From: [Dusty Pilkington](#)
To: ["Cruse & Associates"](#)
Subject: RE: BL-18-00011 Fyall
Date: Tuesday, October 02, 2018 8:06:25 AM

From: [Dusty Pilkington](#)
Sent: Monday, October 01, 2018 3:07 PM
To: ["Cruse & Associates"](#)
Subject: BL-18-00011 Fyall

In the process of reviewing the Fyall BLA, I have some questions.

*Alternate Site Plan*

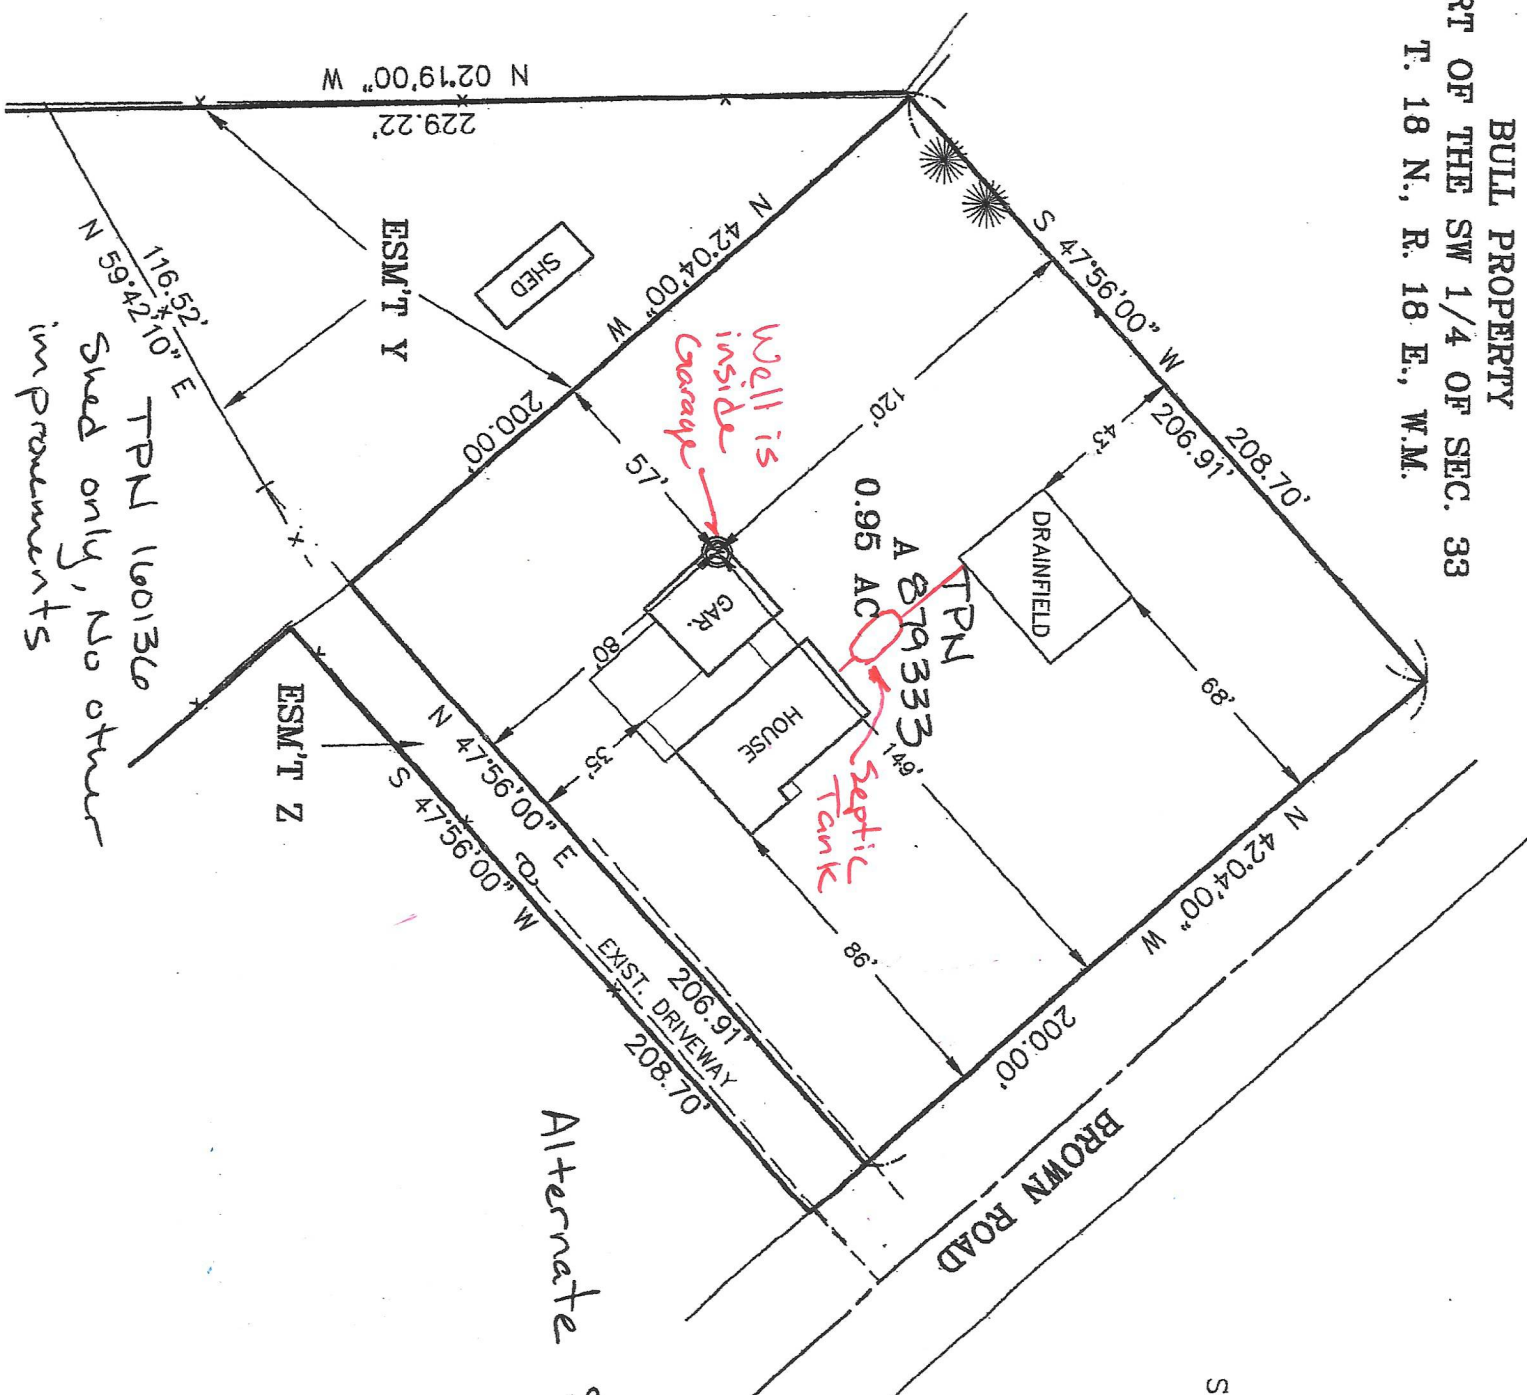
- 1) There is an apparent discrepancy in the acreages shown on the BLA. In the Assessor's records, parcel 879333 has an area of 3.64 acres, and parcel 160136 has an area of 0.95 acres, for a total of 4.59 acres. On your "preferred" site plan the acreages are 1.30 and 3.4 acres, for a total of 4.7 acres. On the "alternate", the acreages are 0.95 and 3.64, for a total of 4.59 acres. Could you explain the discrepancy, and where the extra .11 acres comes from on the "preferred" version?
- 2) A drainfield is shown, but the location of the septic is not. There are no wells drawn, and the narrative makes no mention of whether the or not the parcels are served by a water source other than a well. The site plan or the narrative may require a revision,

You are correct the acreages should exactly match and will ask staff to review first thing in the morning and correct.

**FYALL/BULL PROPERTY**

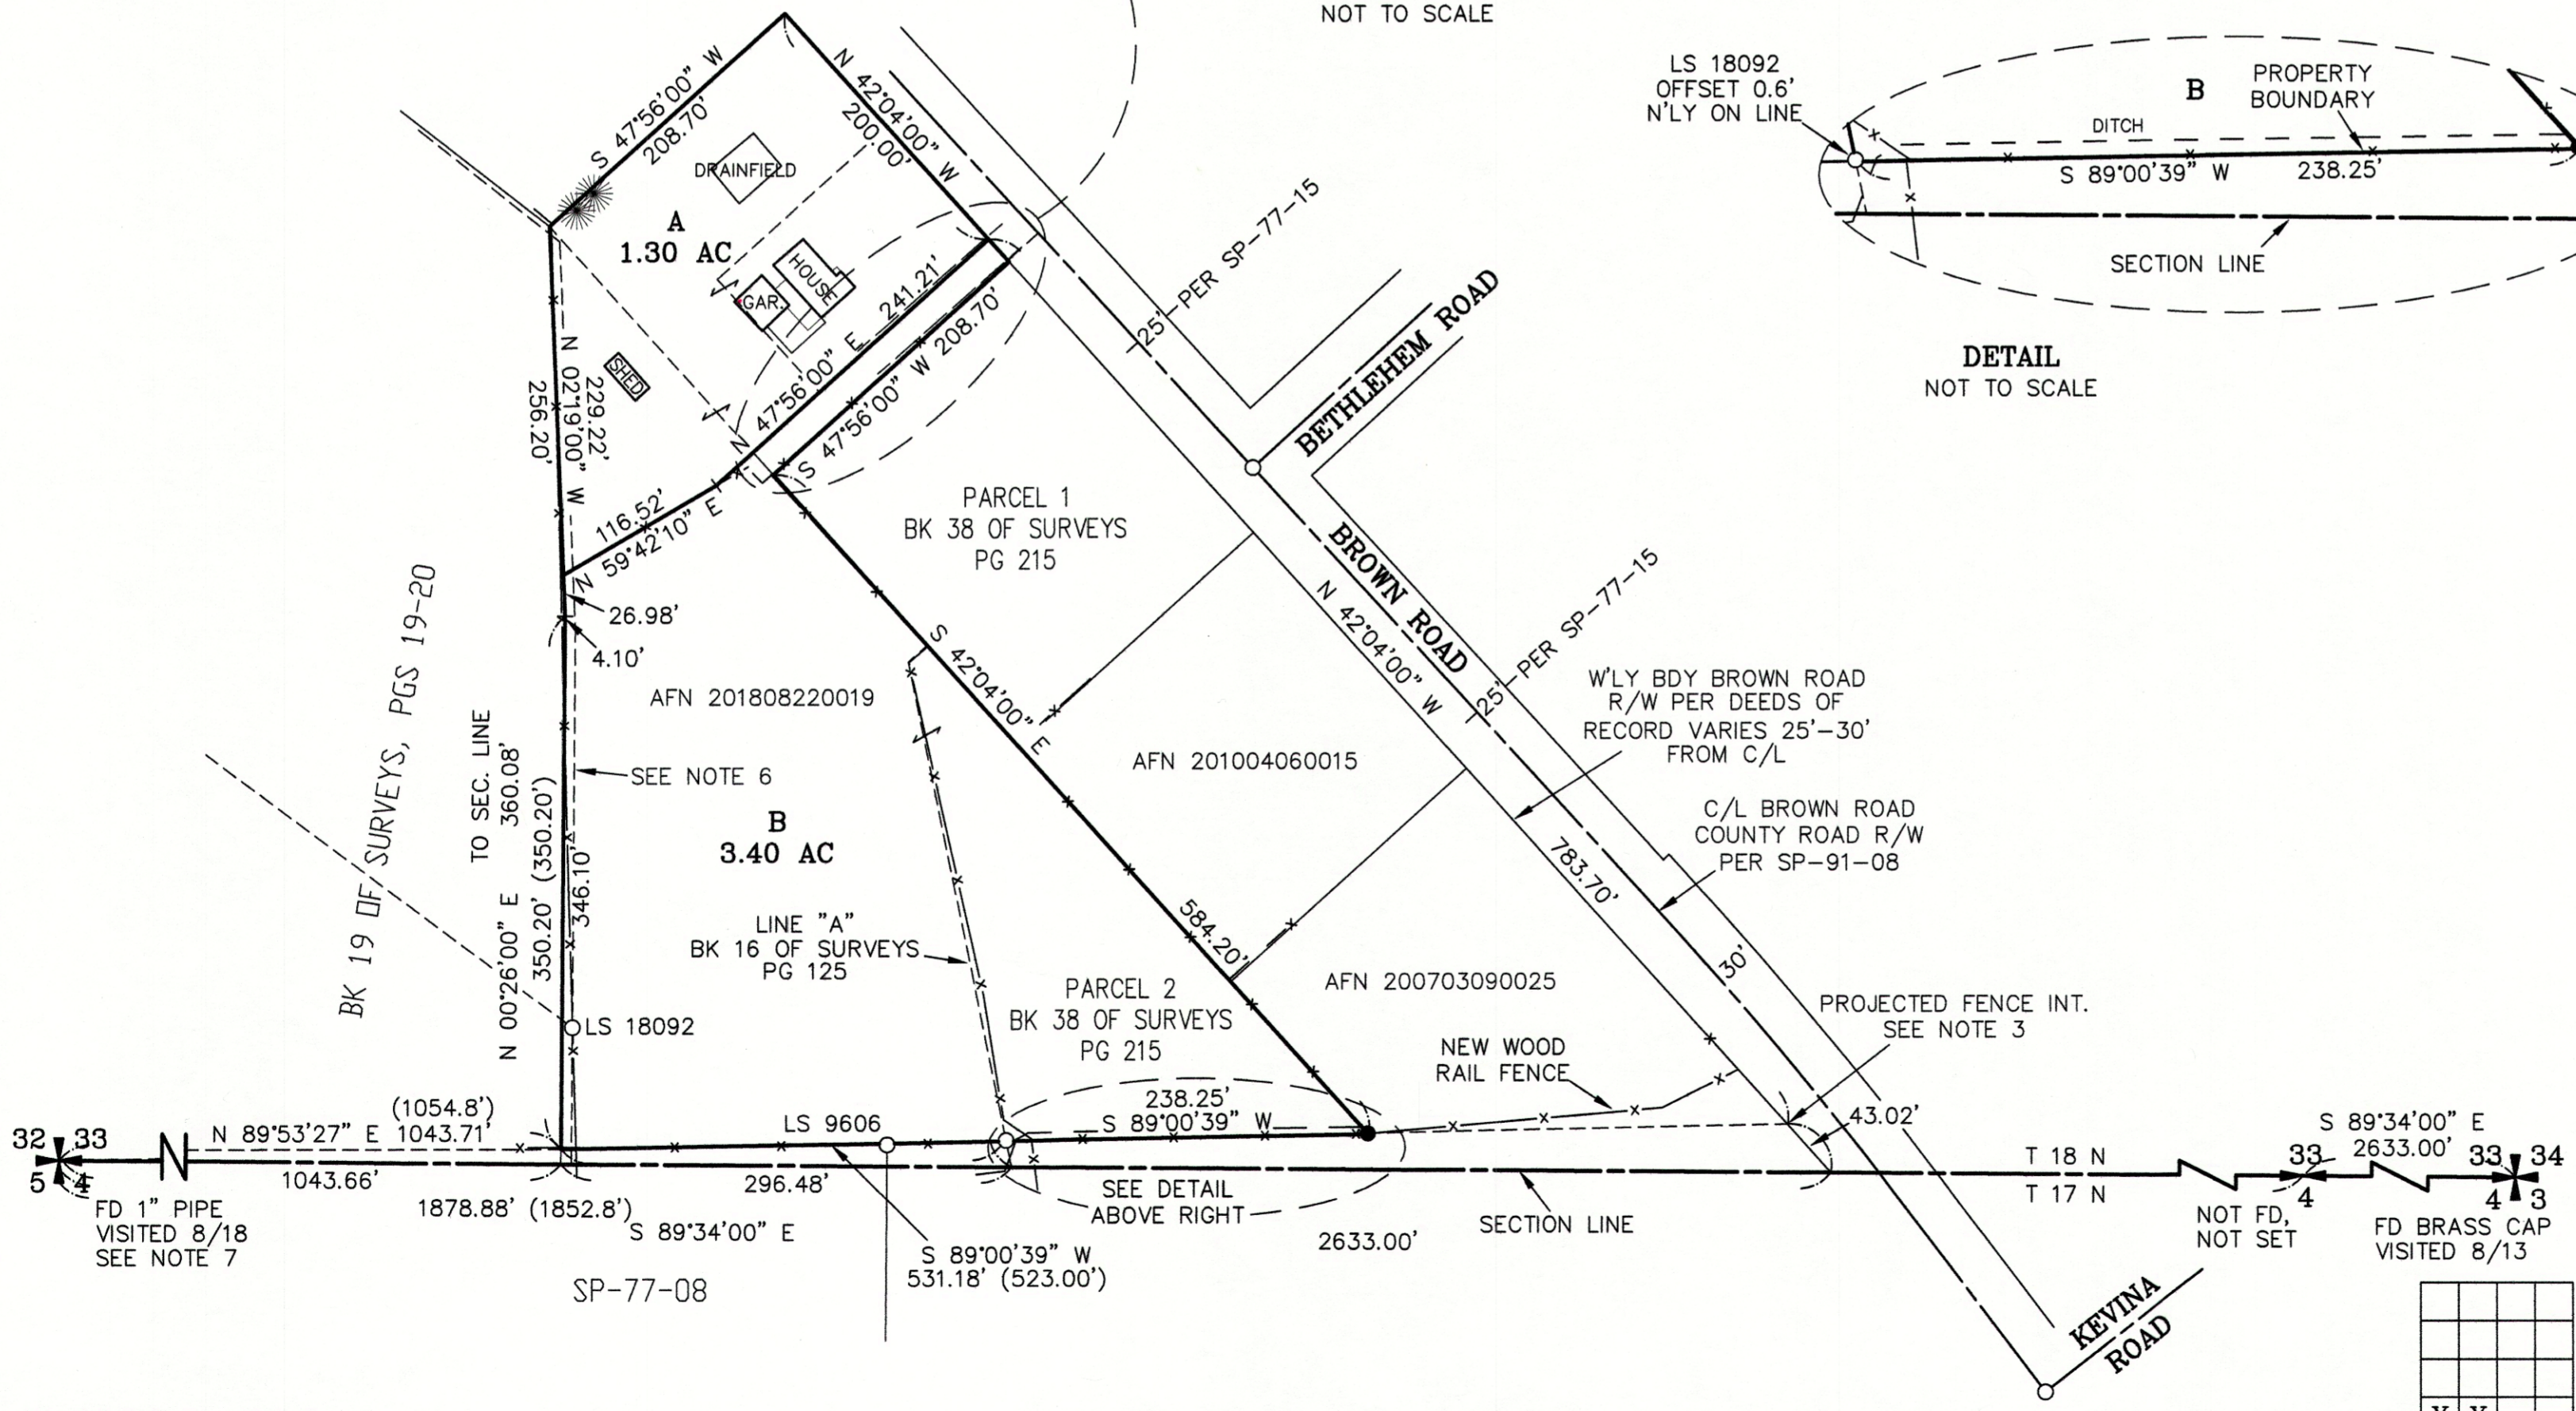
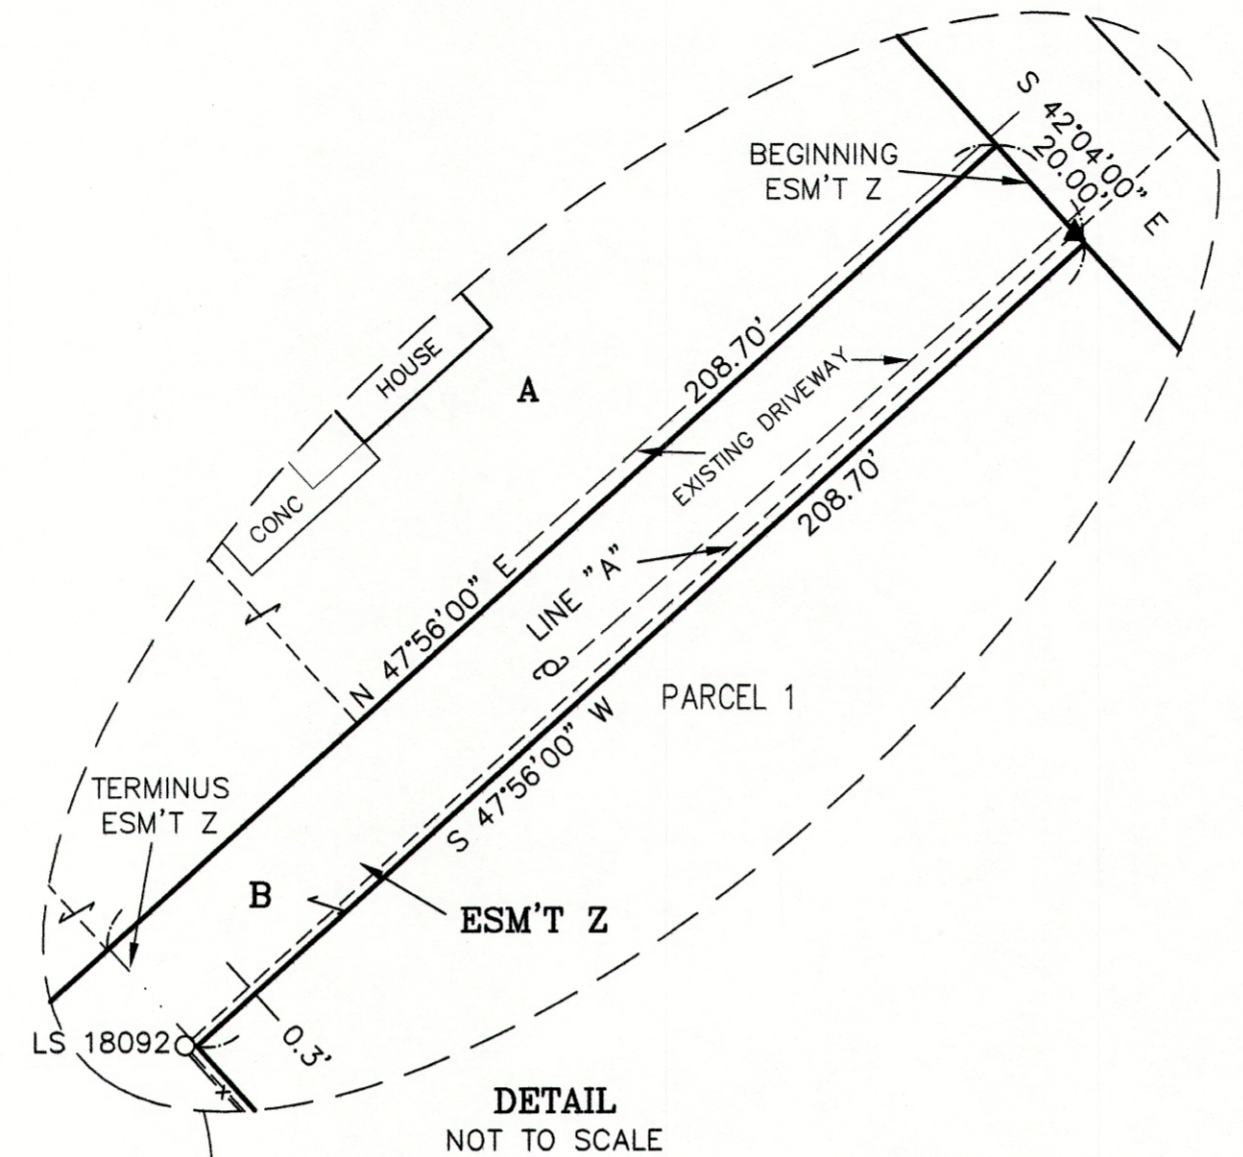
either to depict water source well on the drawing, or to update the narrative to reflect the water source.

The well is inside the garage. I see we listed the well as a symbol in the legend on the survey but is hard to distinguish with the garage walls running through it. Attached is a quick redline of the well location. The septic tank is next to the house and can add it to the site plan while we update. Sorry for the confusion.
